ENGLISH HERITAGE
EAST OF ENGLAND REGION

3 December 2010

**Notifications under Circular 01/2001, Circular 08/2009 & GDPO 1995
FORMER SHREDDED WHEAT FACTORY, BROADWATER ROAD, WELWYN
GARDEN CITY, WELWYN HATFIELD, HERTFORDSHIRE, AL8 6UG
Application No N6/2010/2060/LB**

BROADWATER ROAD WEST, WELWYN GARDEN CITY
 DETAILED PROPOSALS: SHREDDED WHEAT FACTORY
 PRODUCTION HALL BAY STUDIES: EXISTING, PROPOSED & 1920s DESIGN
 568_07_501
 SCALE: 1:50 @ A0; 1:100 @ A2

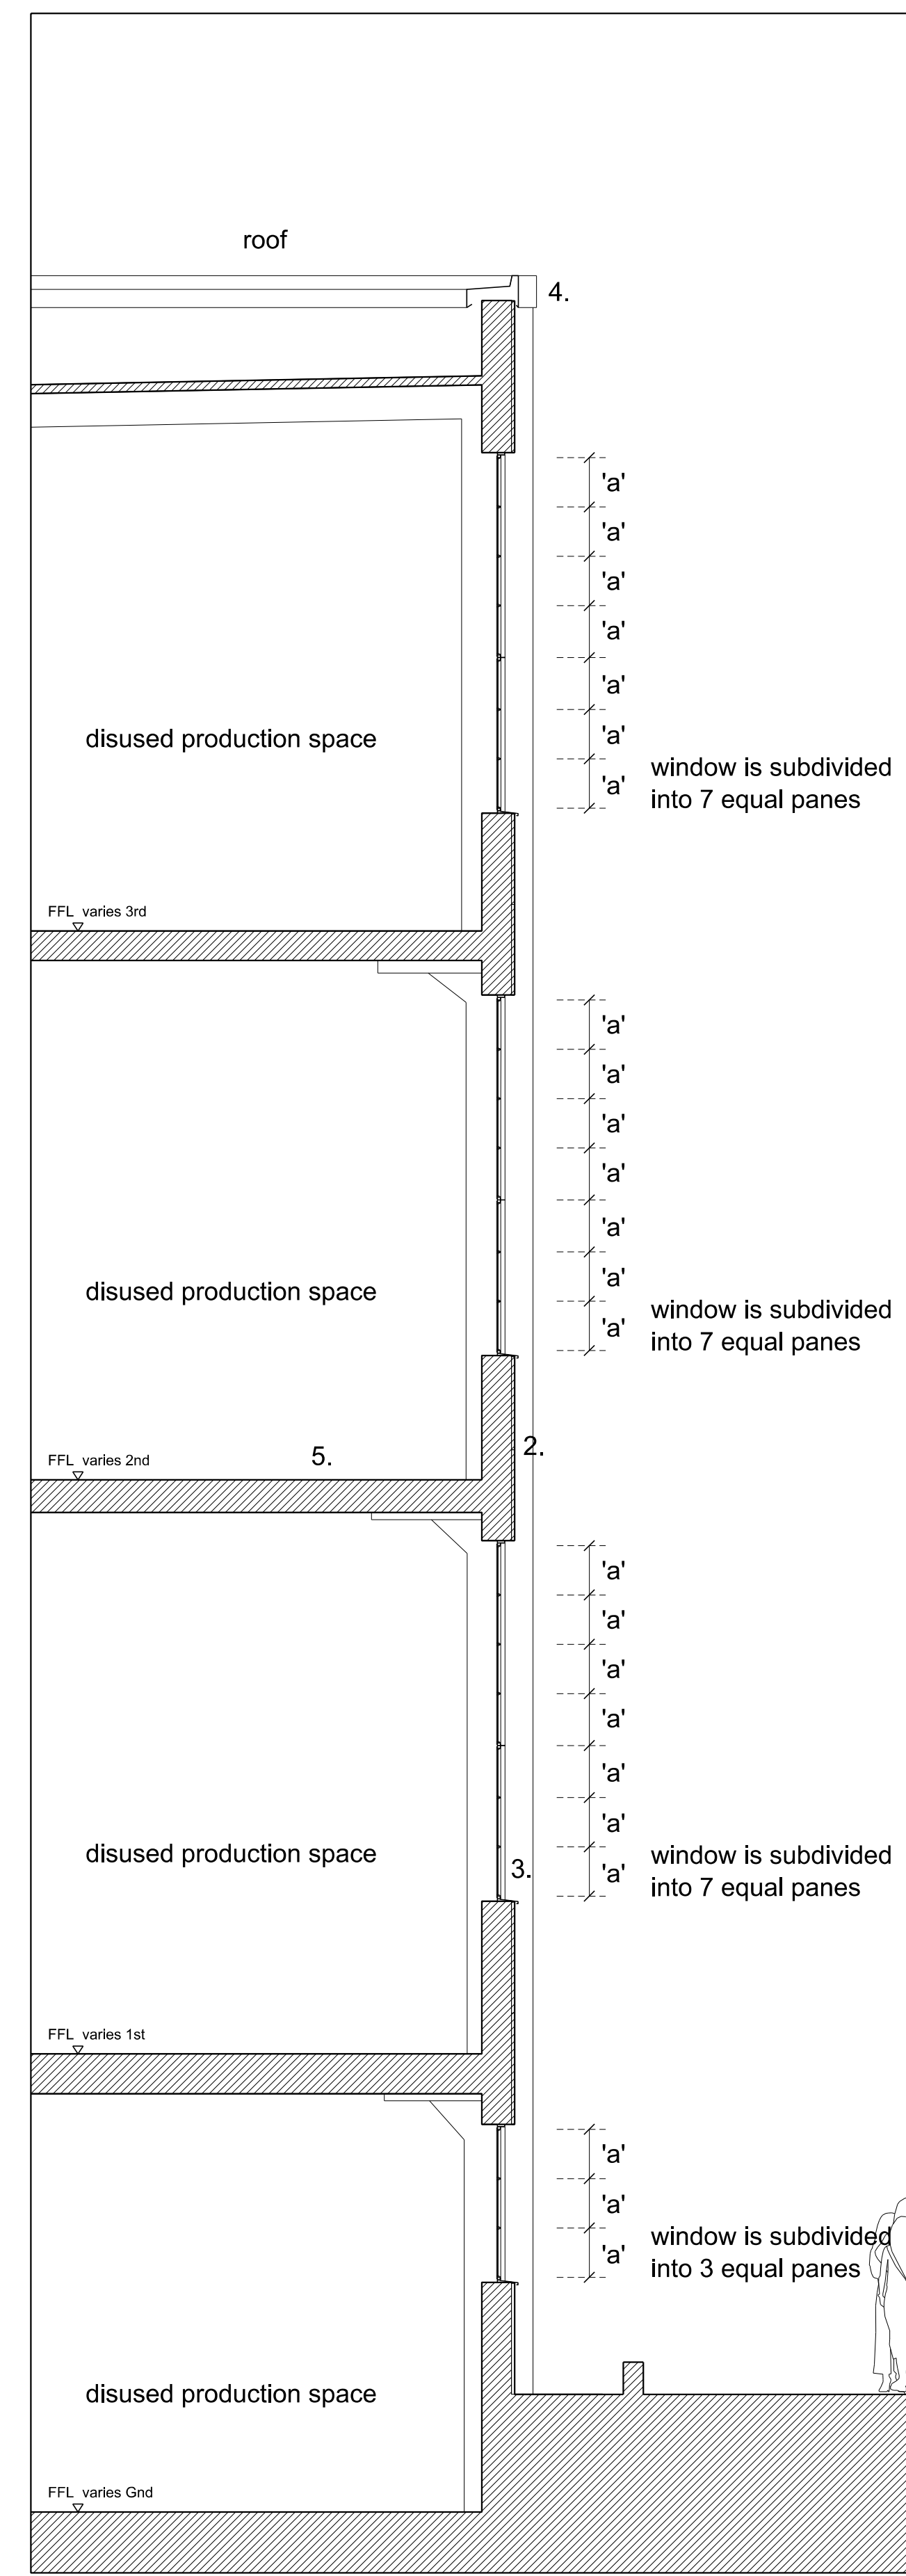
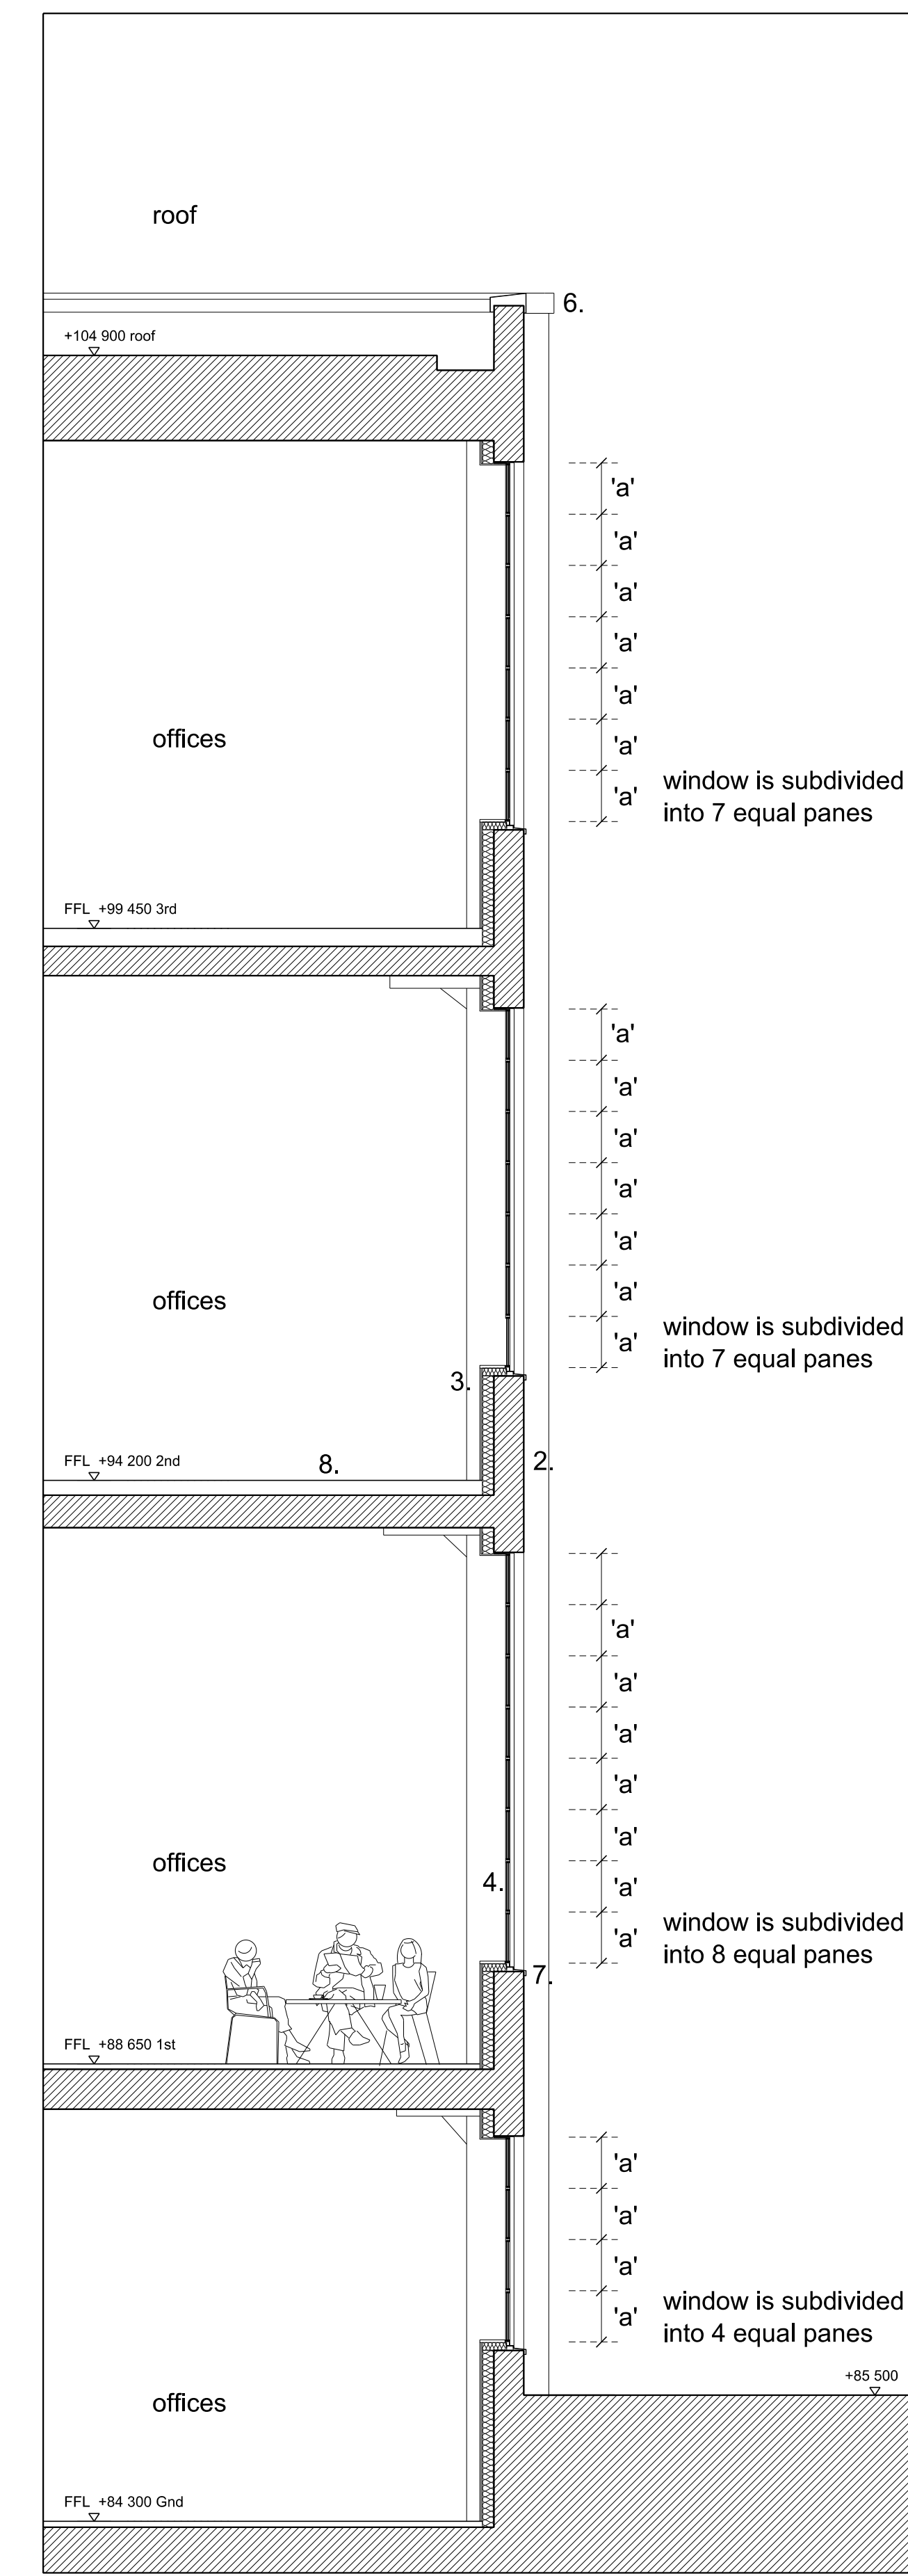
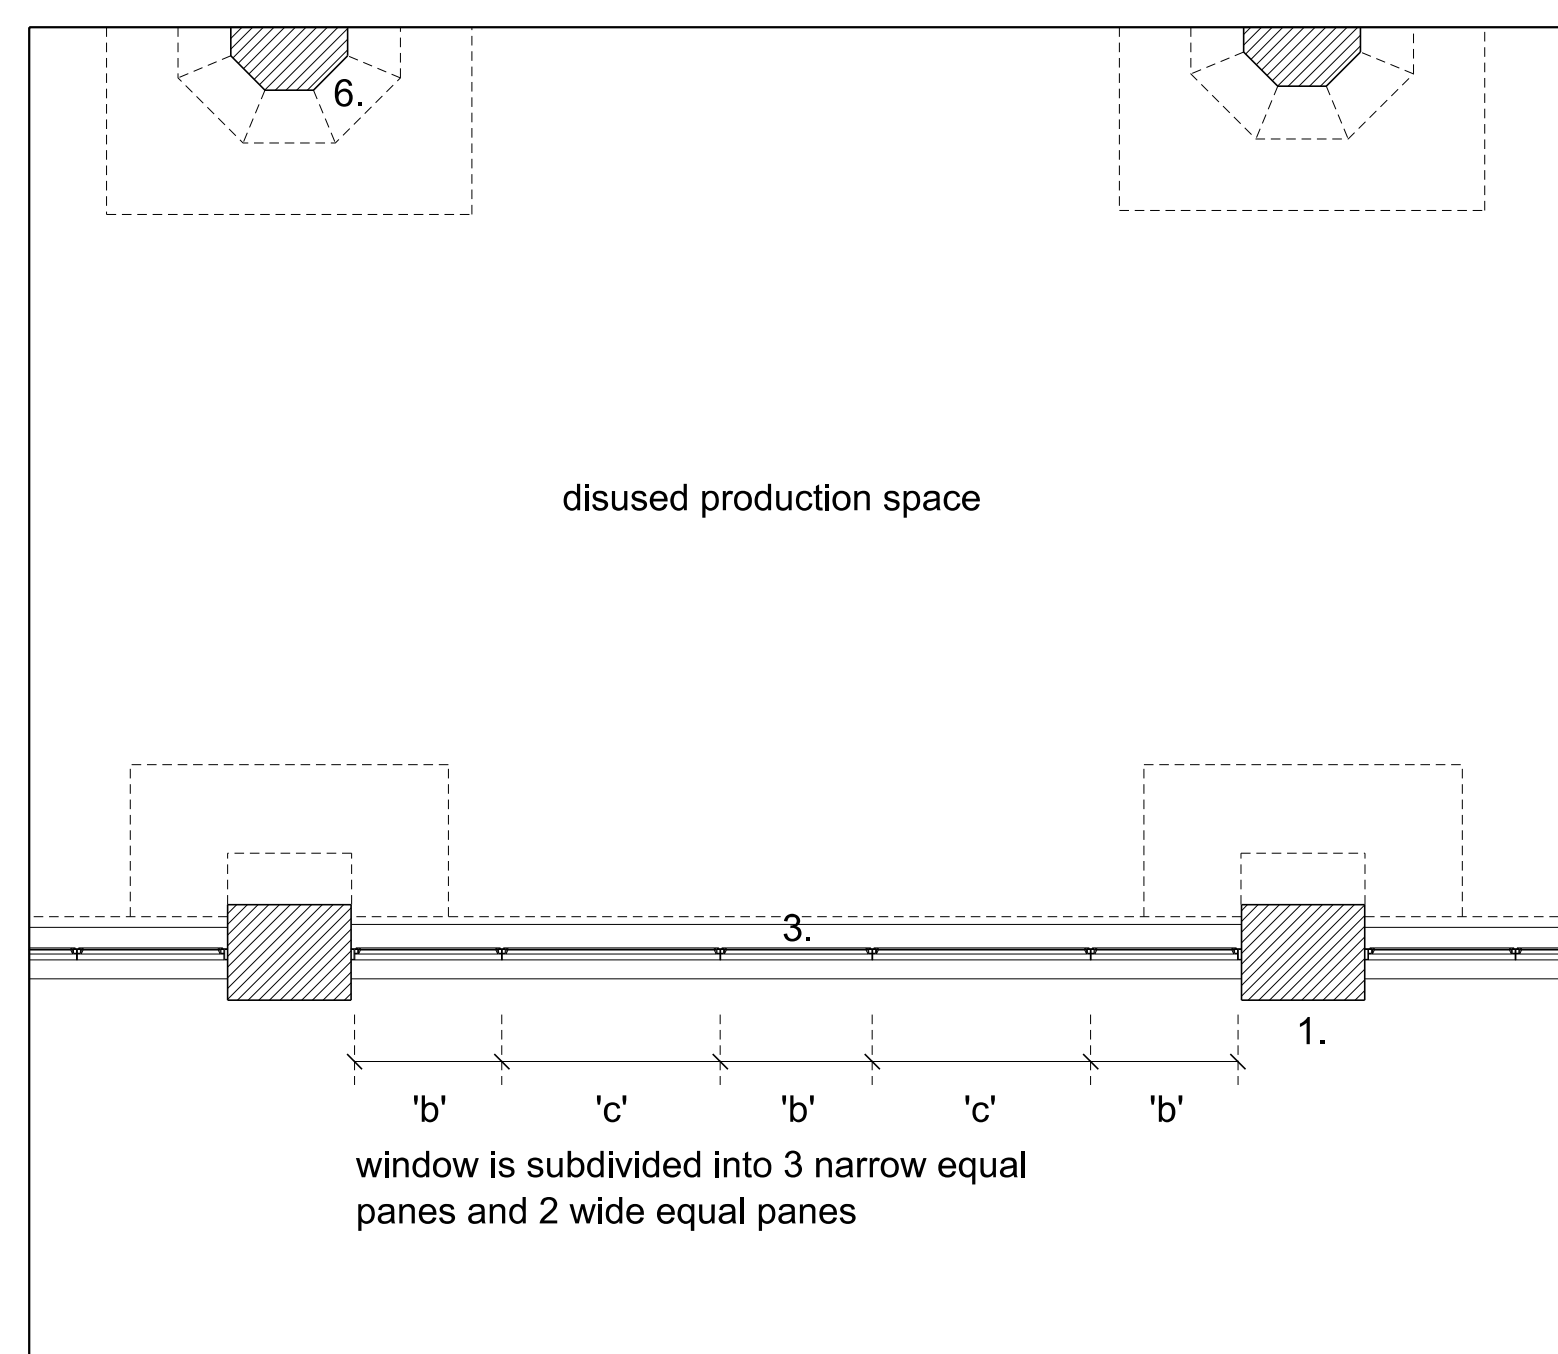
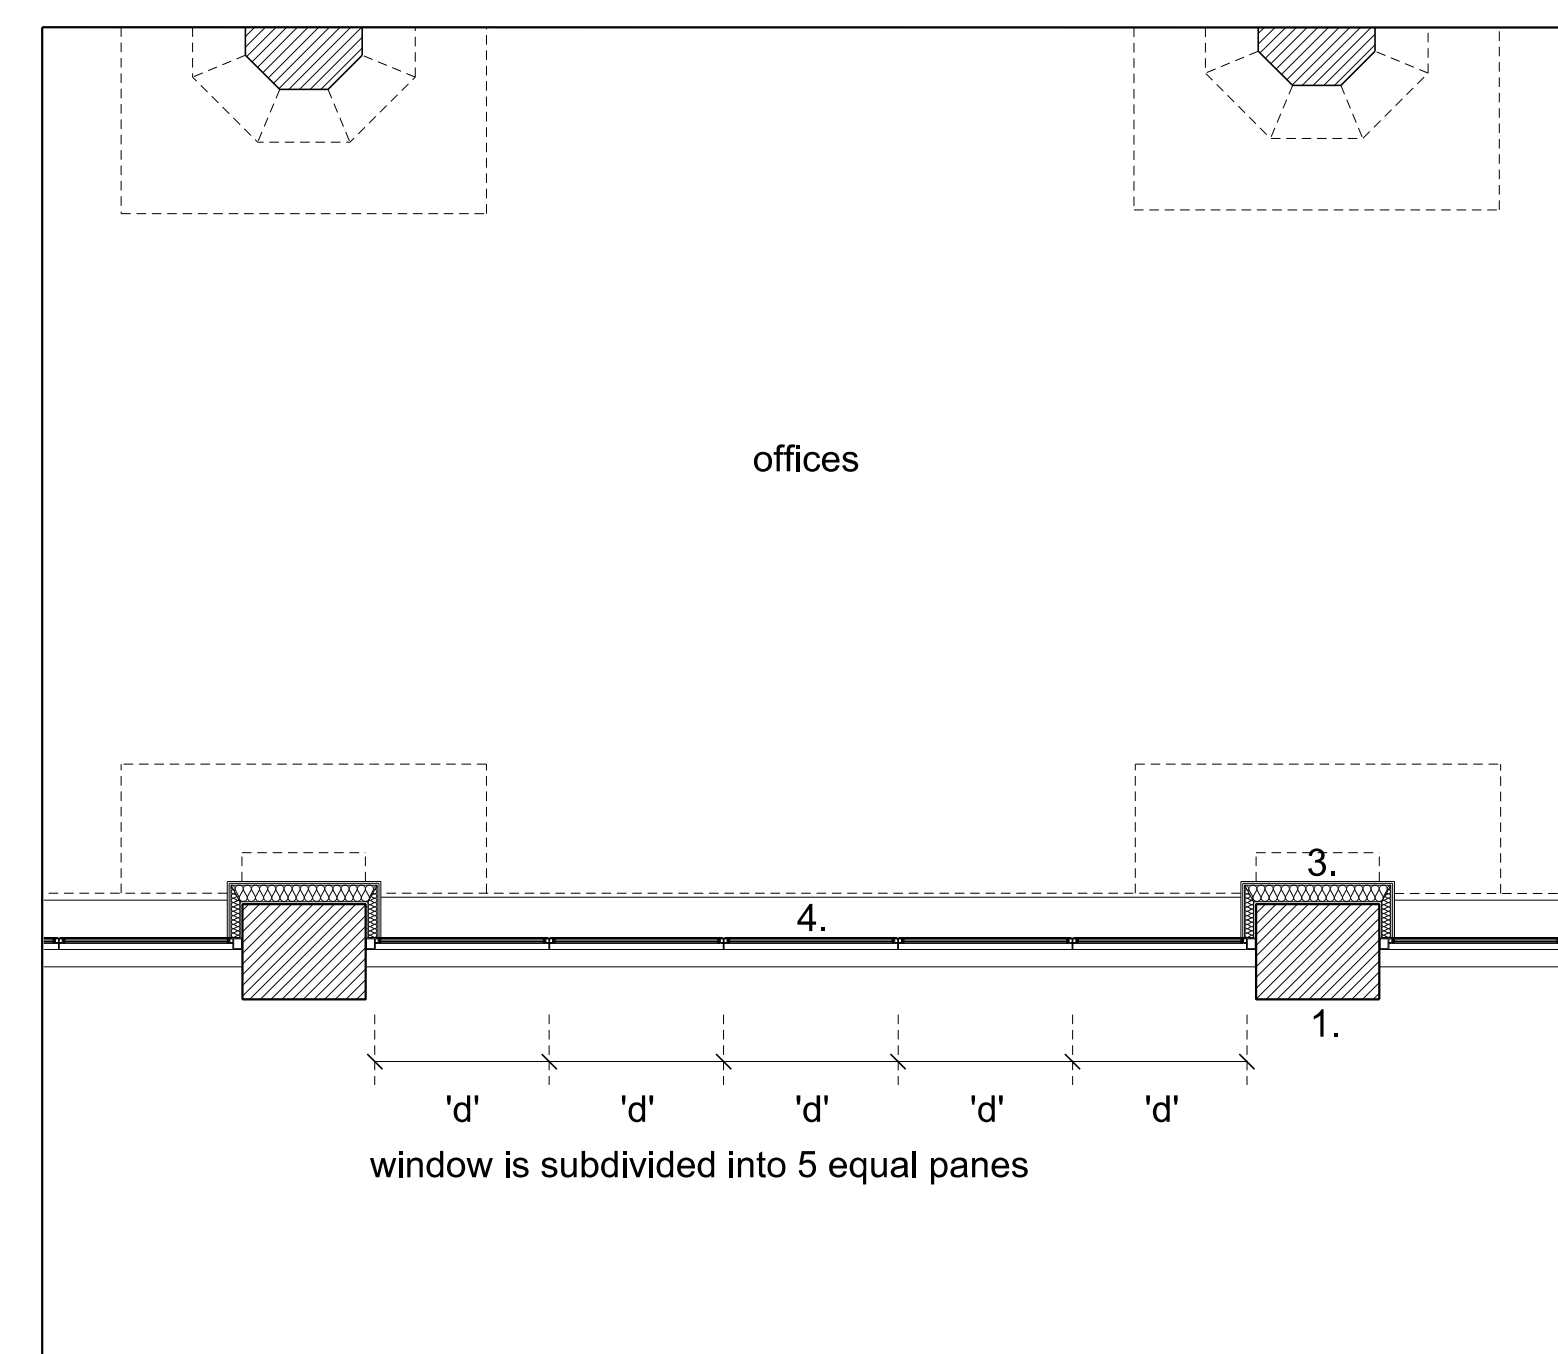
The proposals for the repair, alteration and conversion of the multi-storey factory range, grain and boiler houses and silos are complex and difficult to understand. It is proposed that the multi-storey factory range in particular should be significantly altered, not least by the replacement of its fenestration and by the extension of the upper floor. The submission does not enable these works to be clearly understood, as the annotated drawings are not supported by any explanatory material. A brief but detailed justification should be provided to explain all of these works, to enable the effect of the scheme on the historic fabric of the building and the appropriateness of the proposed works to be assessed.
